Application for a non-material amendment following a grant of planning permission.

Single Storey Rear Extension	
Reference number:	AB/35/20/HH
Date of decision	18/06/2020

Change of colour to the proposed cladding on elevations

**PROPOSED FIRST
FLOOR LAYOUT
SCALE 1:50**

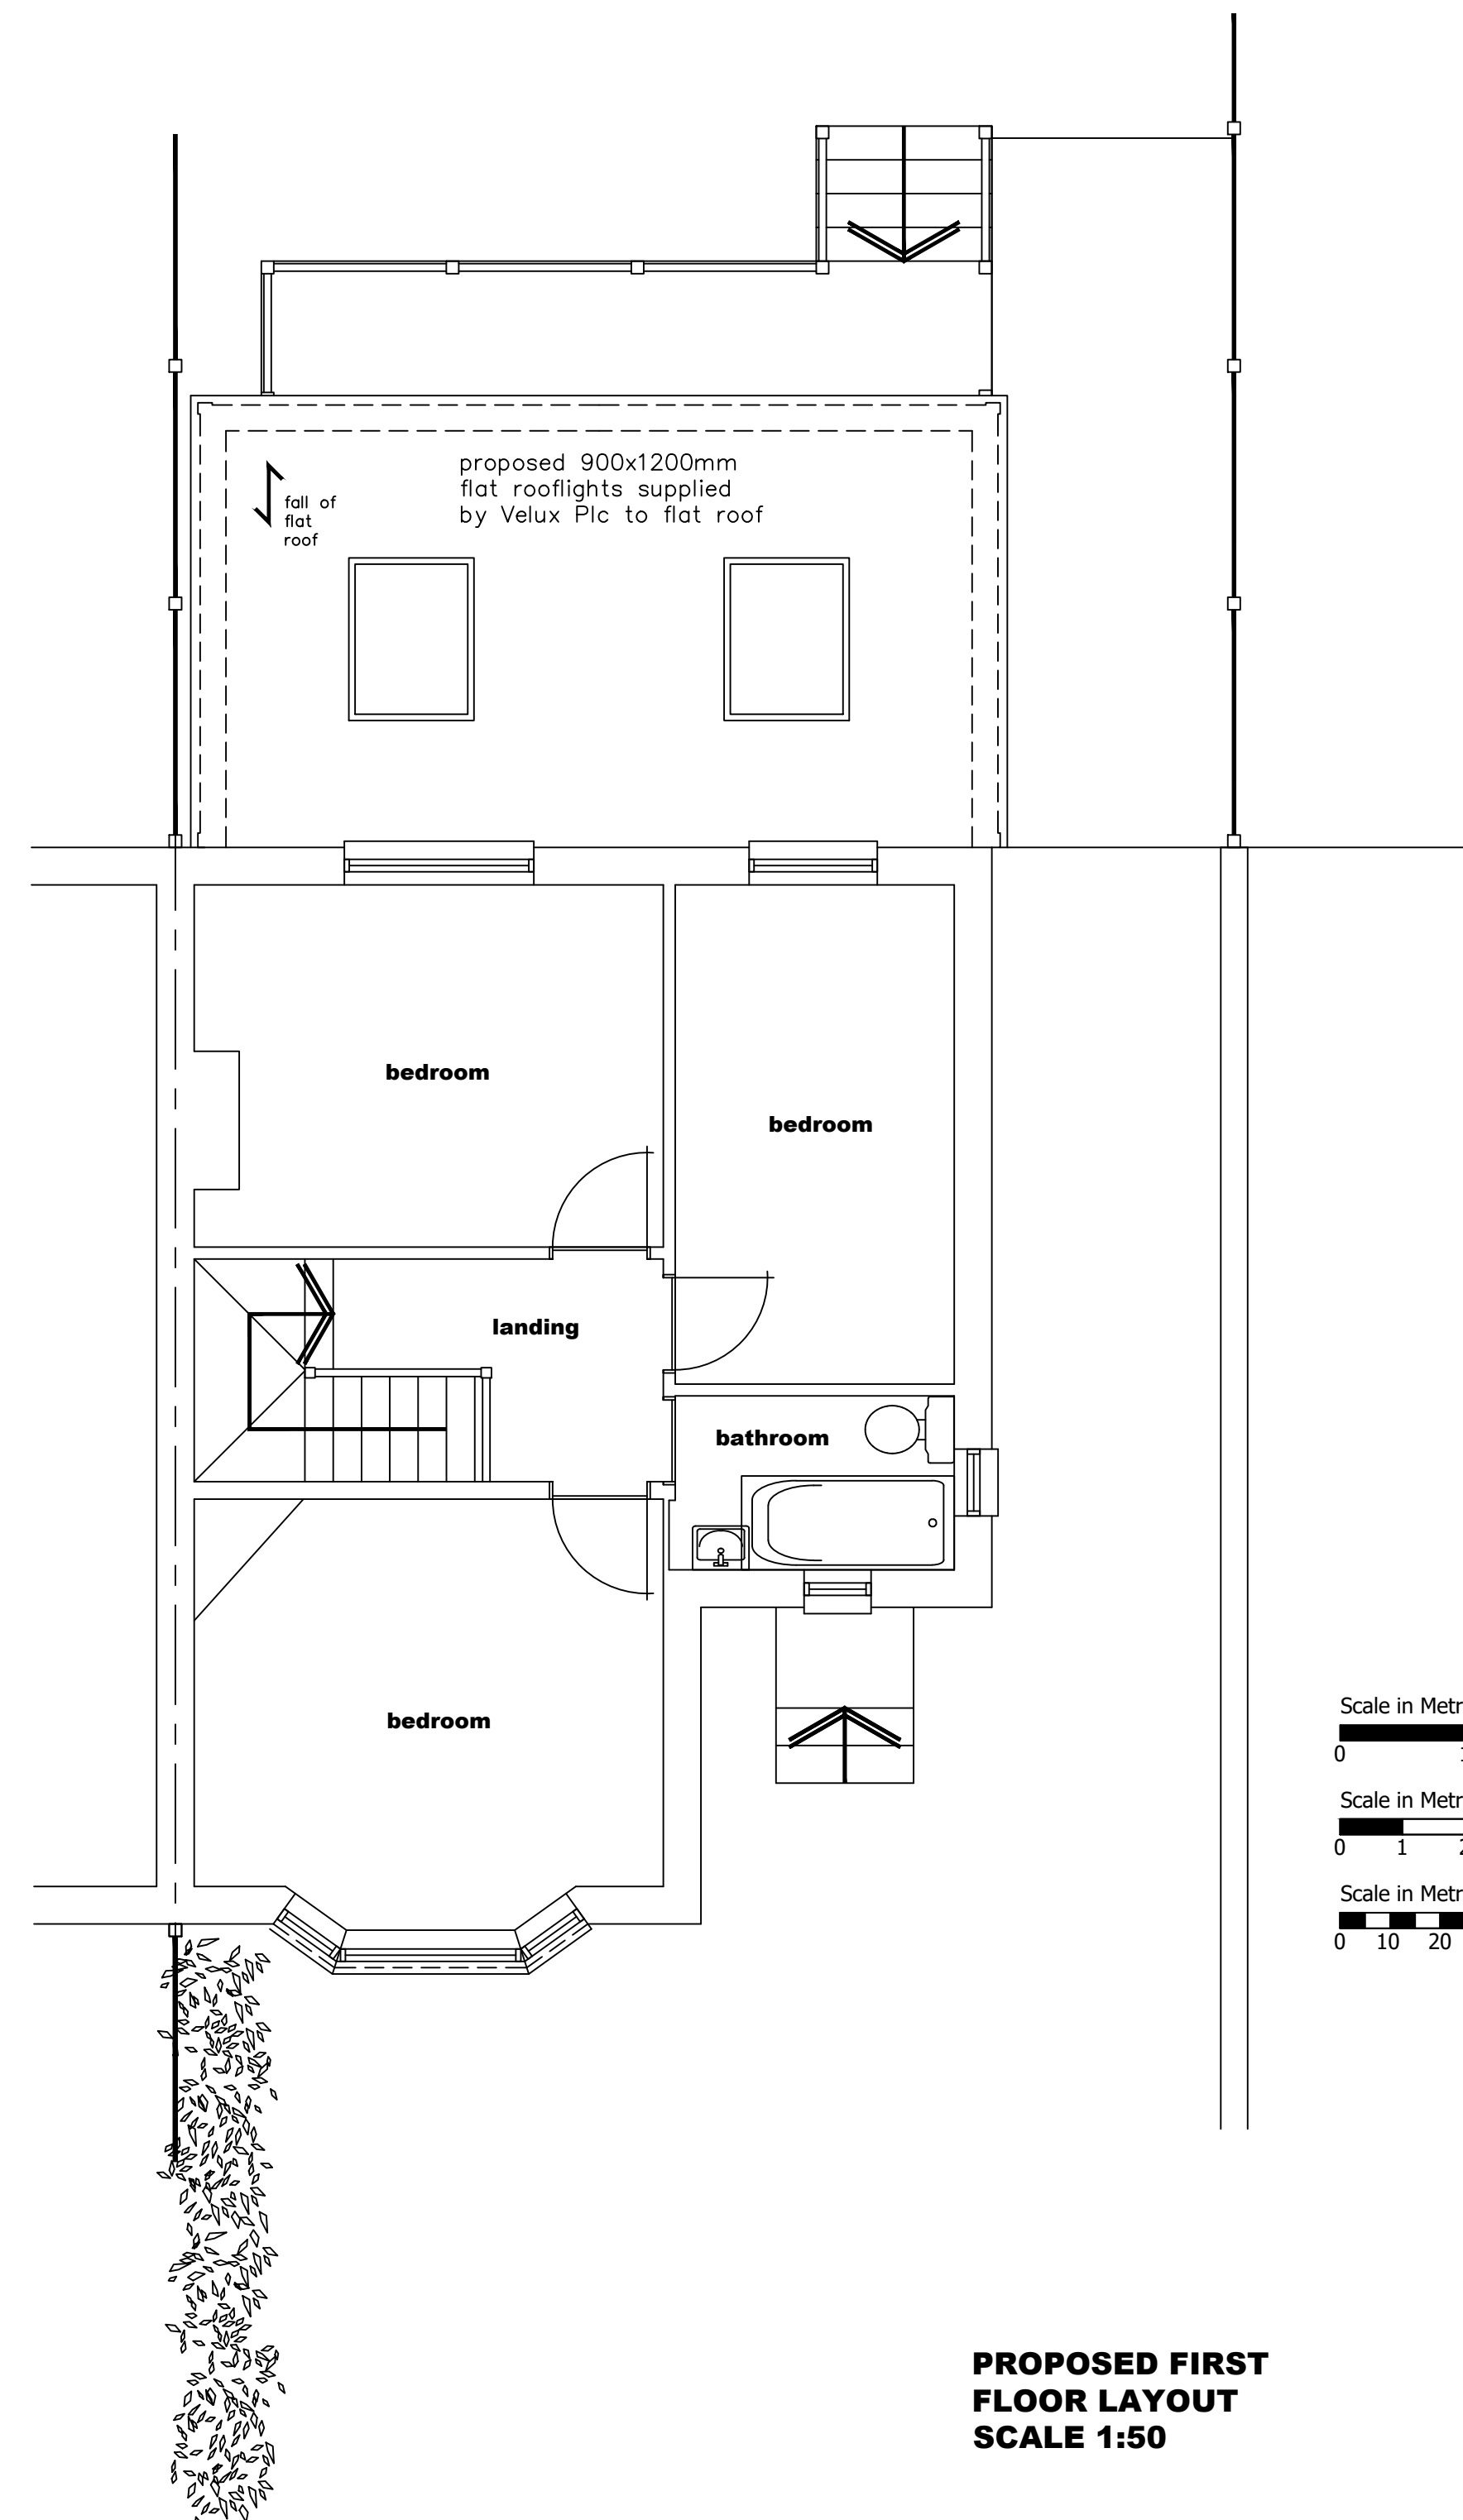
Error in colour selection made by Client prior to original application

15 Howard Road PL rev d-Dwg 2 Prop Gnd-1st-Elevs-S Loc
